**JMT Consulting**  
PO Box 199  
Kingsford NSW 2032  
0415 563 177  
[www.jmtconsulting.com.au](http://www.jmtconsulting.com.au)

27 February 2026

This document provides responses to the traffic and transport related matters raised by the Department of Planning, Housing and Infrastructure (DPHI) and Bayside Council (Council) in their submissions to the site 68-80 Beauchamp Road, Hillsdale (SSD –83256478).

**LONGITUDINAL SECTION
DRIVEWAY EDGE 1**

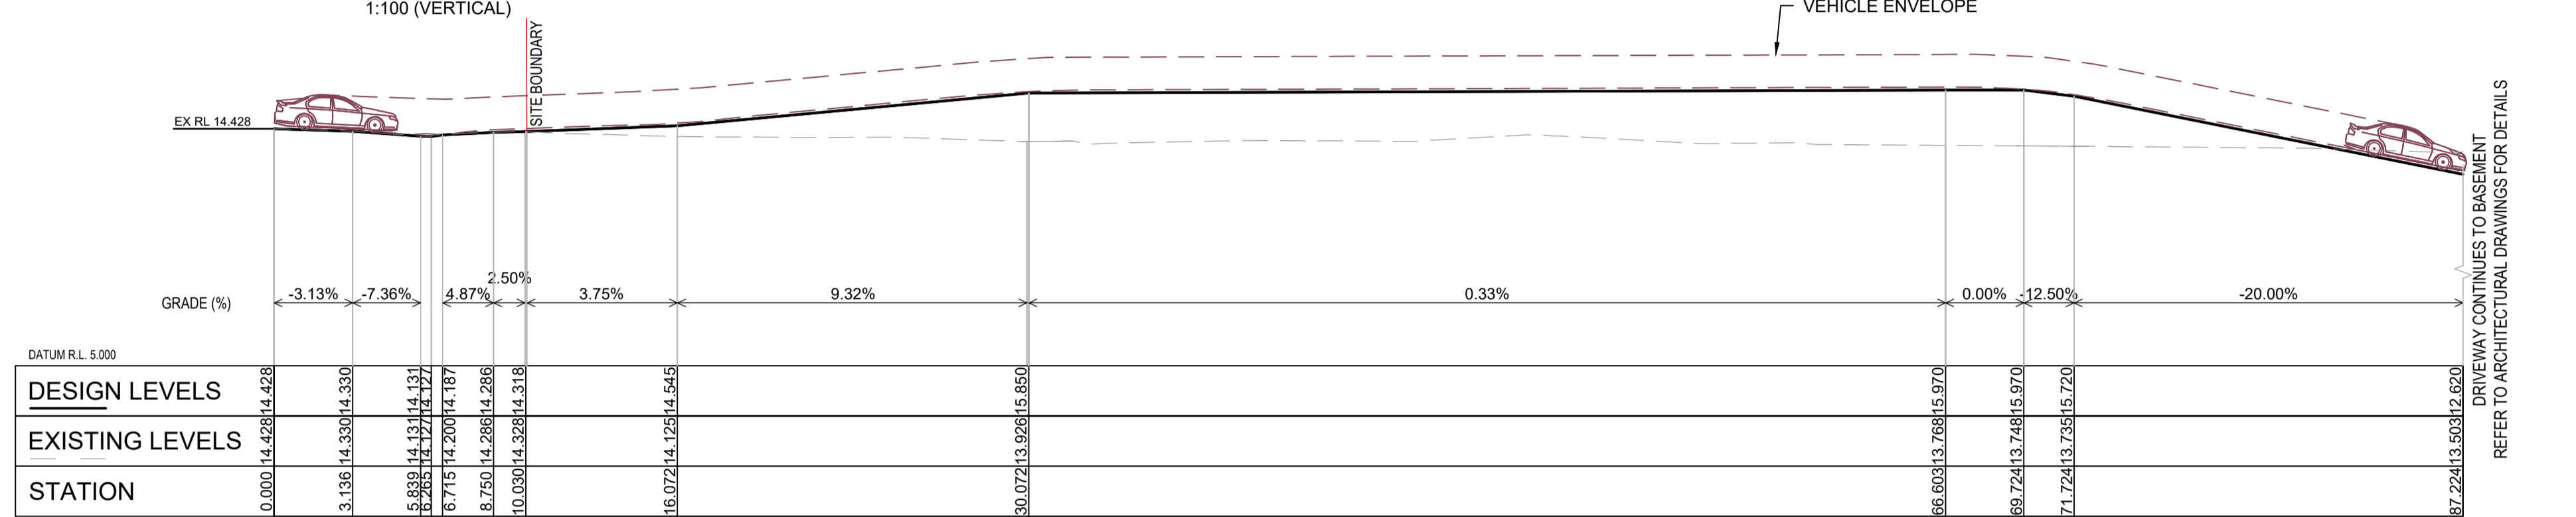
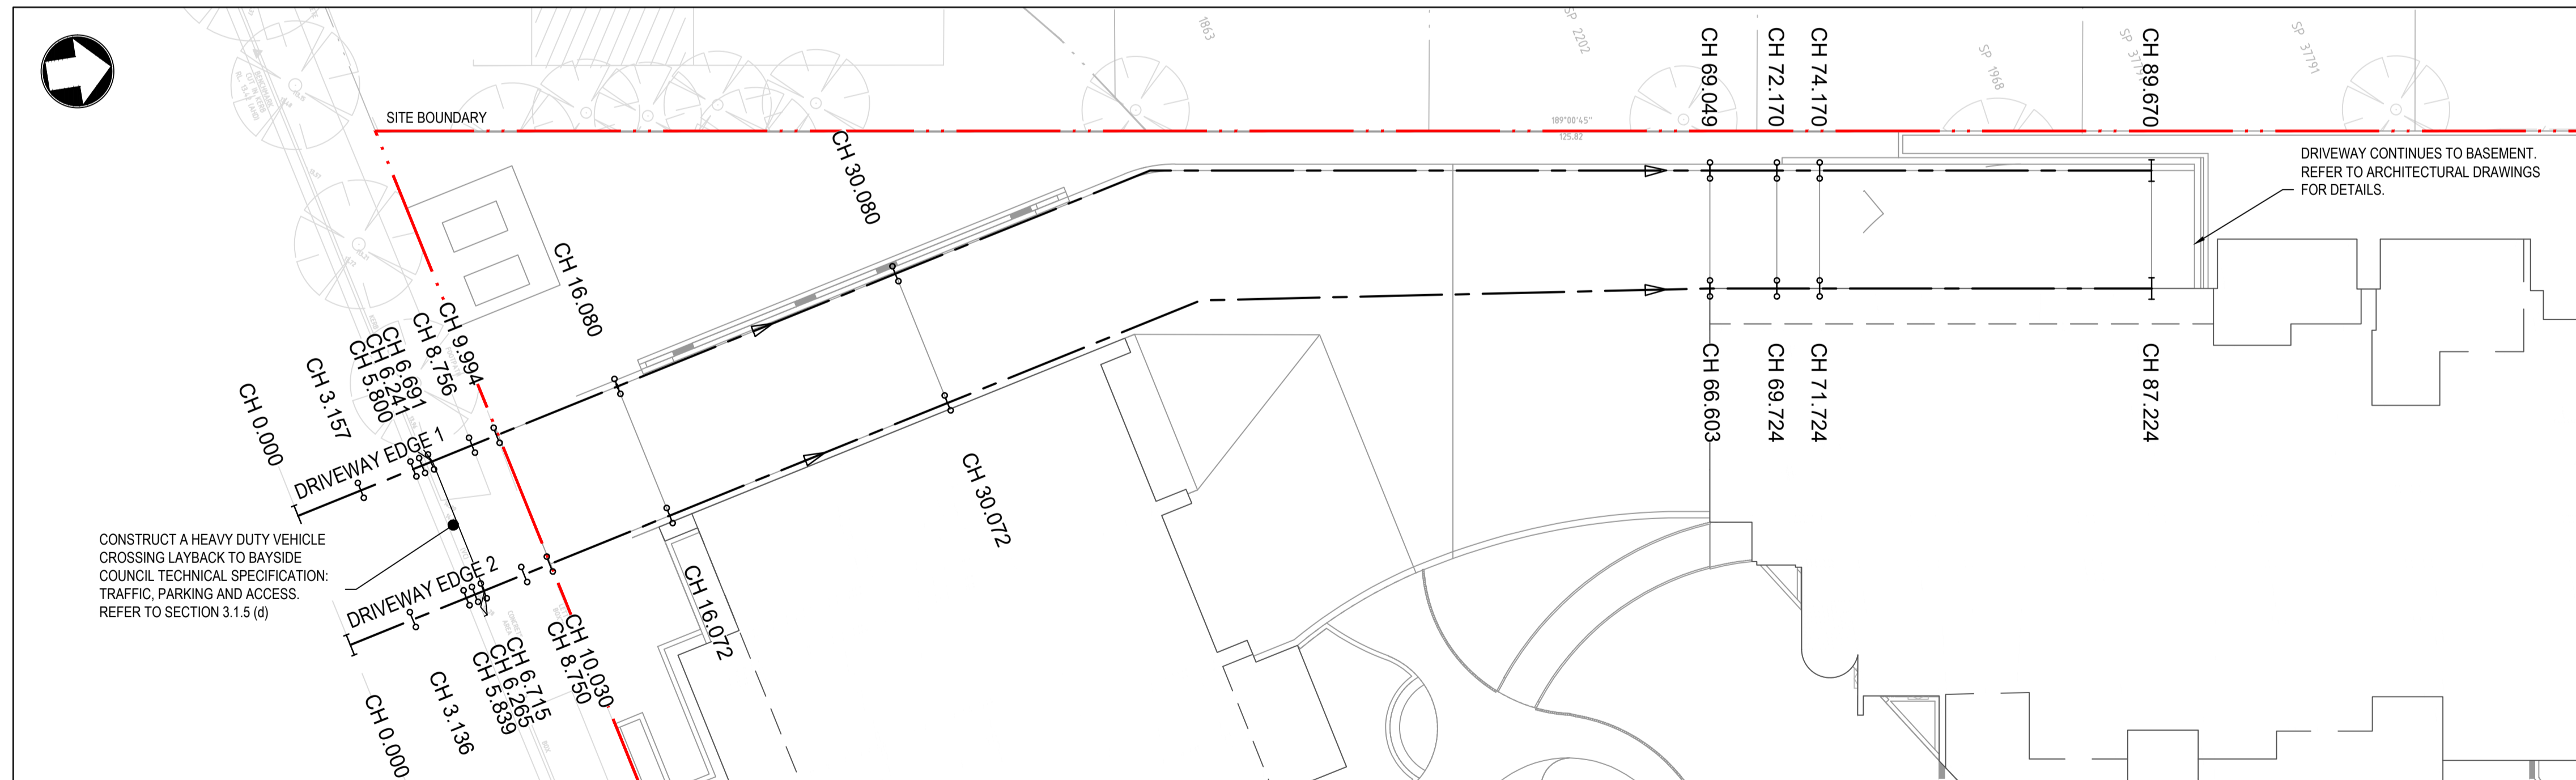
<p>Driveway design:</p> <ul style="list-style-type: none"> <li>A longitudinal driveway profile prepared by a civil engineer shall be provided for the proposed driveway with a vertical ground clearance test of the largest vehicle proposed to use the driveway (Council garbage truck as detailed in Section 13.5 of Bayside Waste Management Technical Specification).</li> <li>A longitudinal section plotting headroom clearance along the travel path of the service vehicle(s) is to be provided.</li> <li>It must be demonstrated that a safe headroom clearance of 4.5m is achieved along the entire travel path, parking, and manoeuvring areas of the MRV and Council garbage truck within the development.</li> </ul>	<p>Refer to civil engineering drawings prepared by Mott Macdonald for response to this item. The Council waste collection vehicle will not physically enter the building basement and therefore be afforded with unconstrained headheight along its path of travel.</p>
